## **SUMMARY OF REPRESENTATIONS MADE AT ISH2 AND ISH4 SUBMITTED BY NATIONAL HIGHWAYS LIMITED**

### **APPLICATION BY GATWICK AIRPORT LIMITED (THE APPLICANT) FOR AN ORDER GRANTING DEVELOPMENT CONSENT FOR THE GATWICK AIRPORT NORTHERN RUNWAY PROJECT (THE PROJECT)**

Section 7 - Airport Way Westbound (Railway Bridge To North Terminal Flyover)

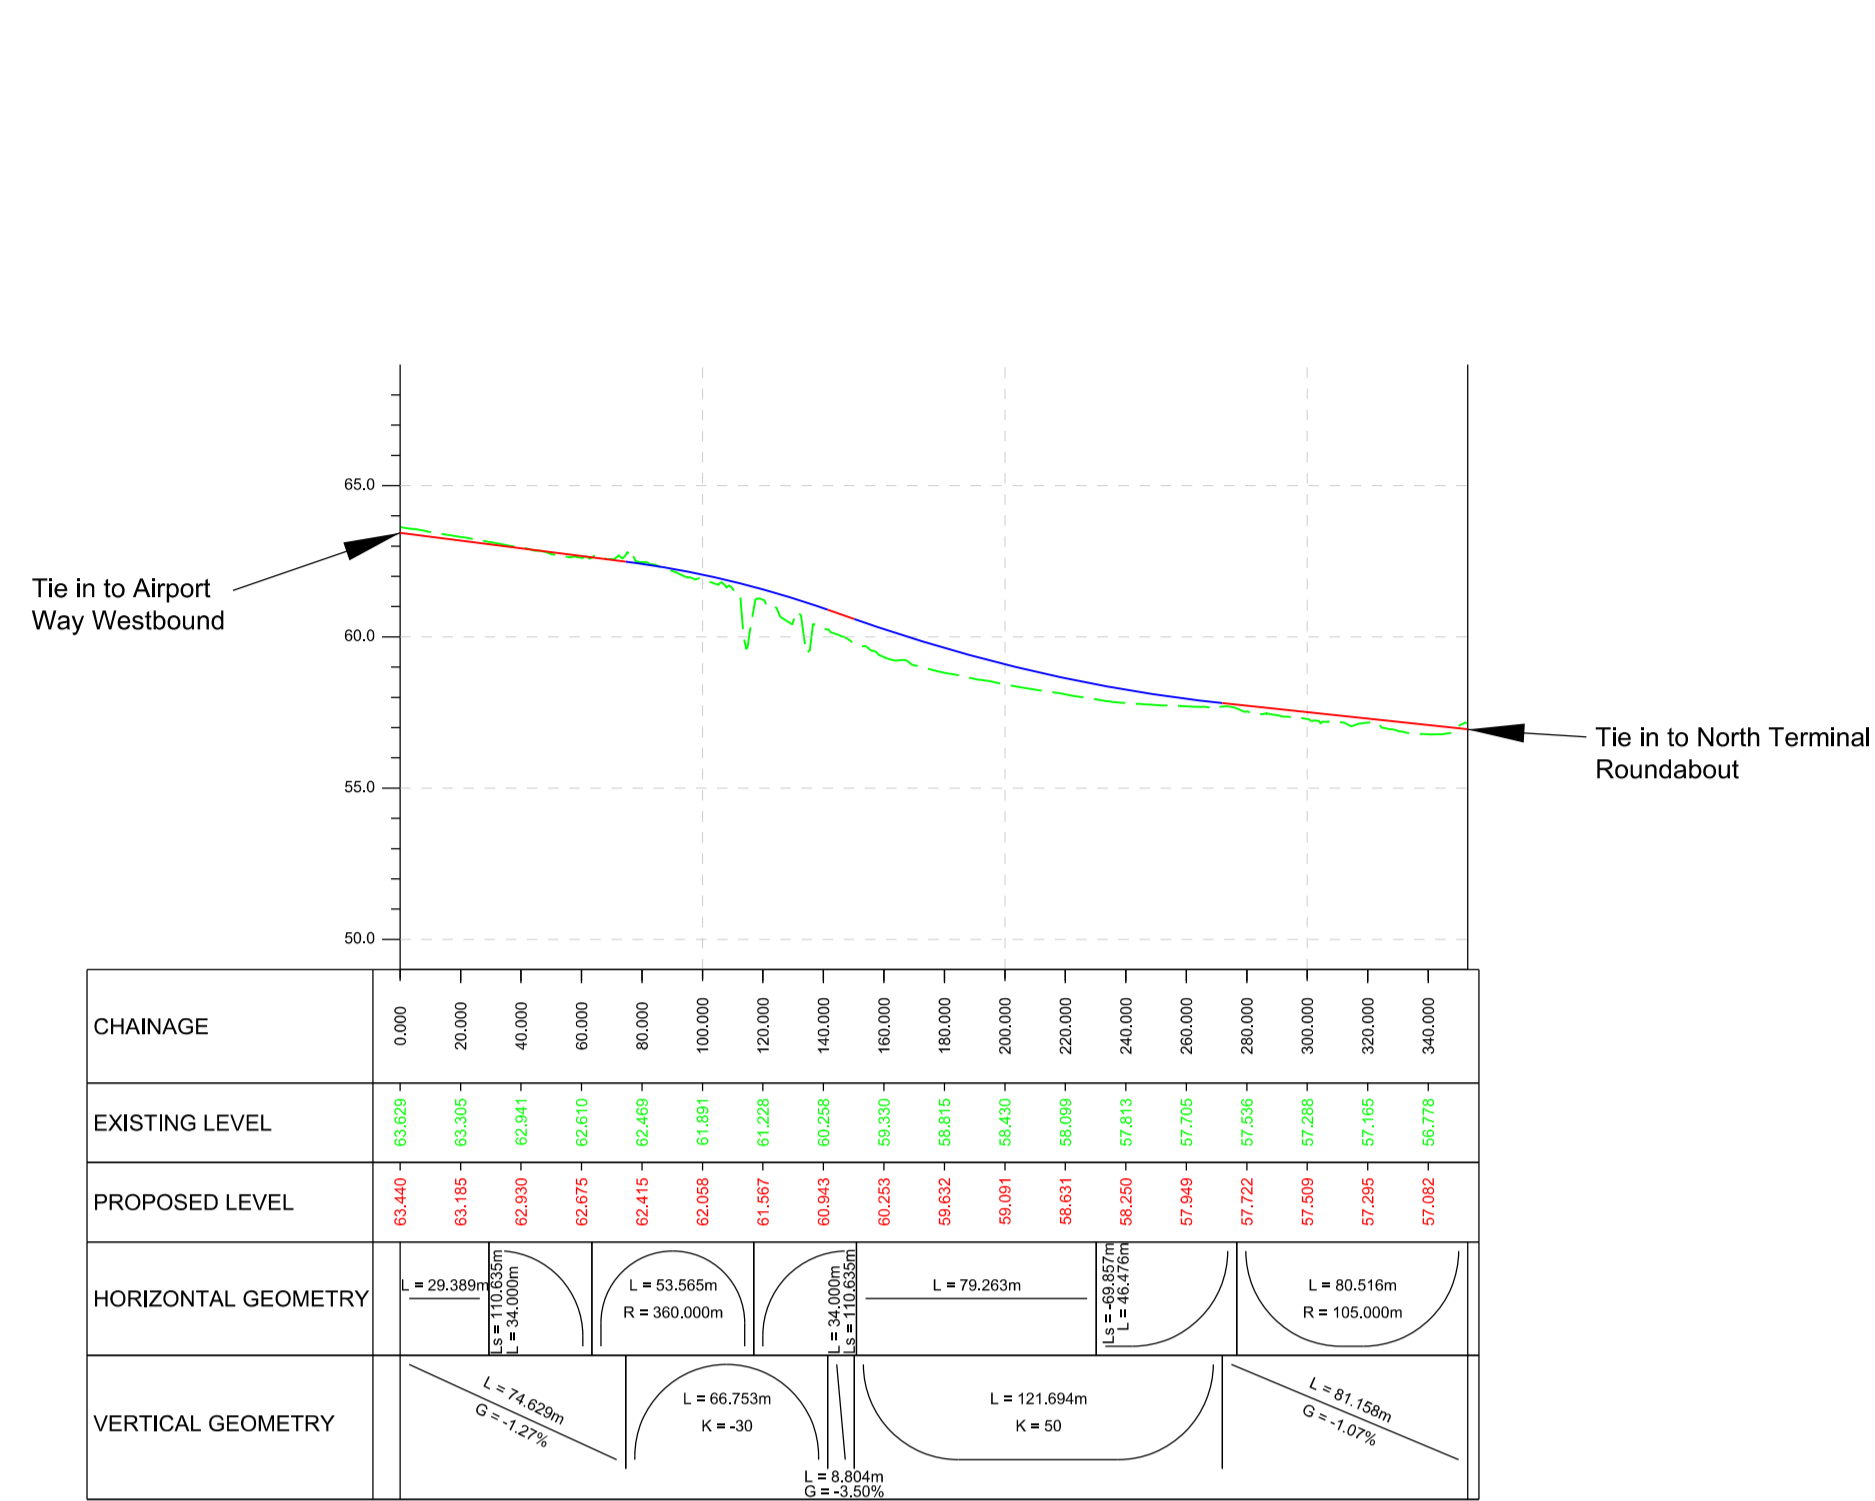
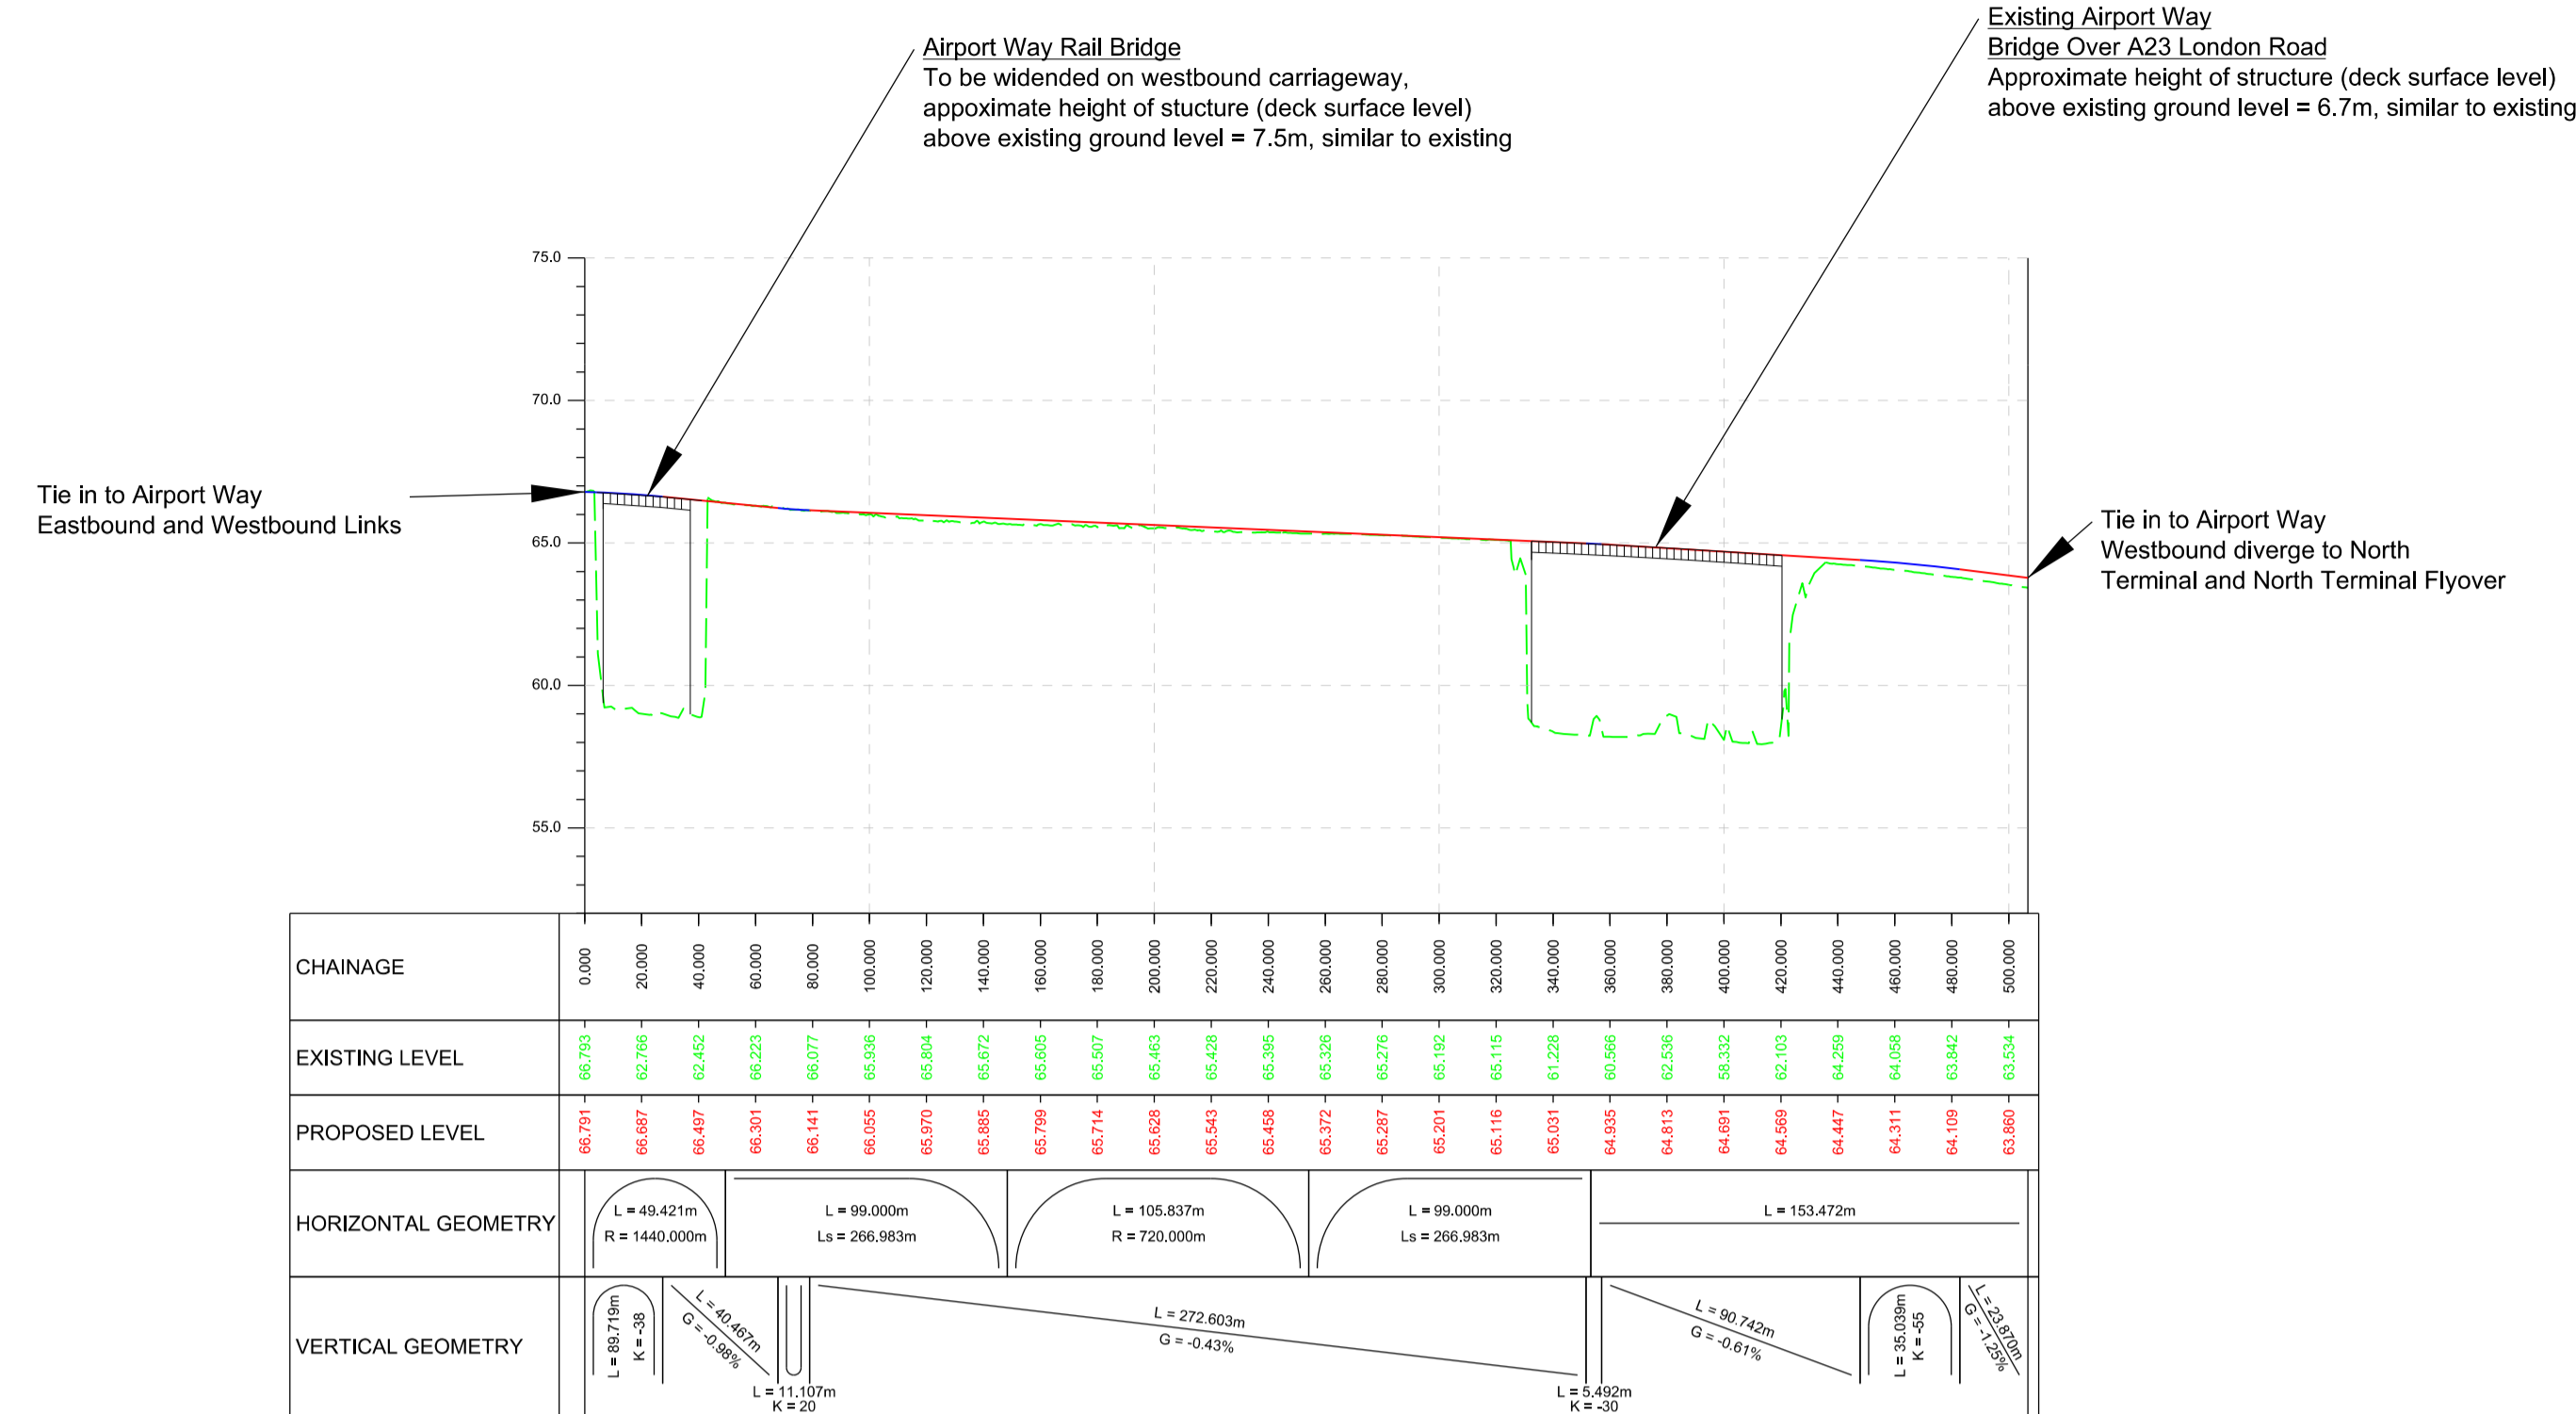
- 2.22 National Highways' view is that there is insufficient modelling available on the construction impacts of the proposed development. The timing of these construction works may need to be staggered in order to avoid adverse impacts on the SRN. By way of example: For the proposed Airport Way Railway Bridge Works, National Highways notes that Stage two would require lane one of the Westbound carriageway to have a full closure, which would include peak time operation.
